DOC18/268585  
SSD 8658

**Gunnedah Solar Farm (SSD 8658)- Public exhibition**

**ATTACHMENT A****OEH Detailed Comments****Gunnedah Solar Farm – Environmental Impact Statement**

Figure 3: Field Plan for Project Area

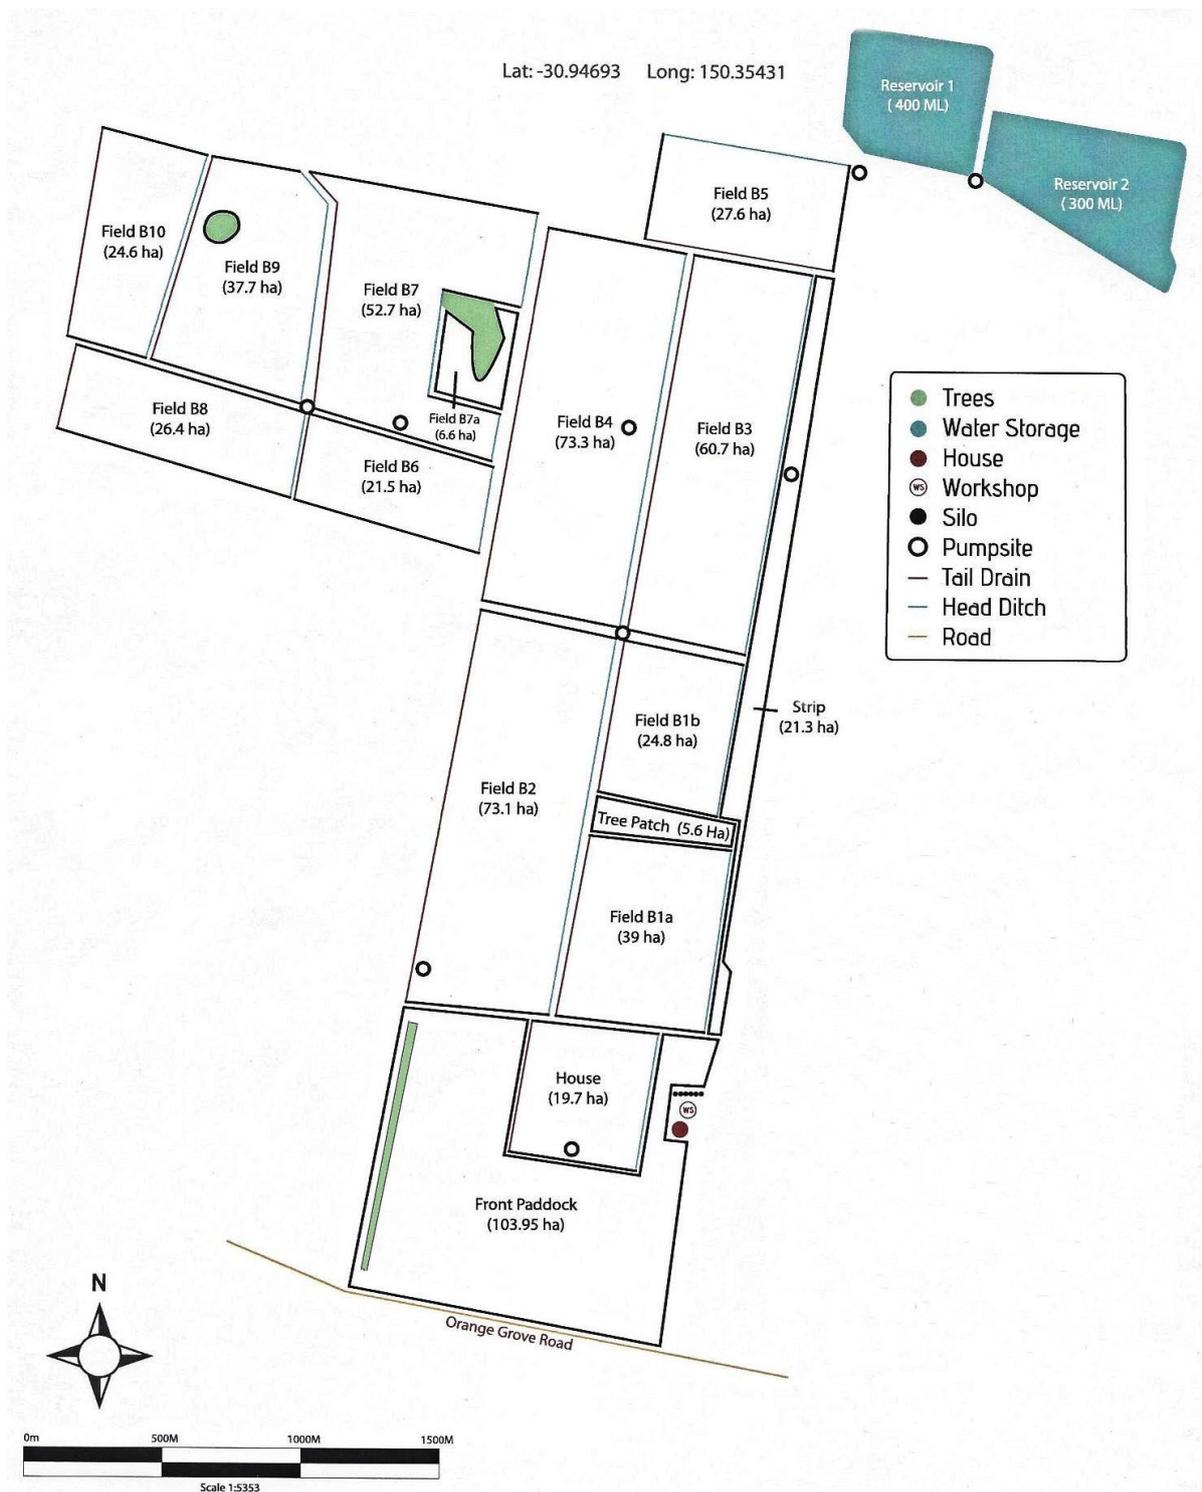
The flora assessment assigned Plant Community Types (PCTs) to native vegetation stands (named B1, B7 and B9) on the lots to be impacted by the solar farm. The assessor has matched all three areas of native vegetation to PCTs equivalent to endangered ecological communities (EECs). No shapefiles, plot data or site value scores have been provided.

Conflicting information is presented on whether the proposal will impact the native vegetation mapped on the site. Whilst the flora assessment states that none of the identified native vegetation on the site

will be impacted, the fauna assessment refers to the removal of trees, stating that *'the main cumulative impact associated with the proposal is the loss of the 15 trees in field B1'* (page 20). The fauna assessment proposes replacing the trees lost from field B1 by selective replanting in the buffer zones around the site (page 24). The flora assessment considers the B1 vegetation zone to conform with the listings for three different EECs.

1. Resolve the contradictory information in the EIS and confirm the extent of the proposed impacts on the site on native vegetation and threatened species habitat.
2. Update the threatened species assessment to include details of the nearby common planigale record and evaluate the likelihood of this species occurring on the solar farm site.
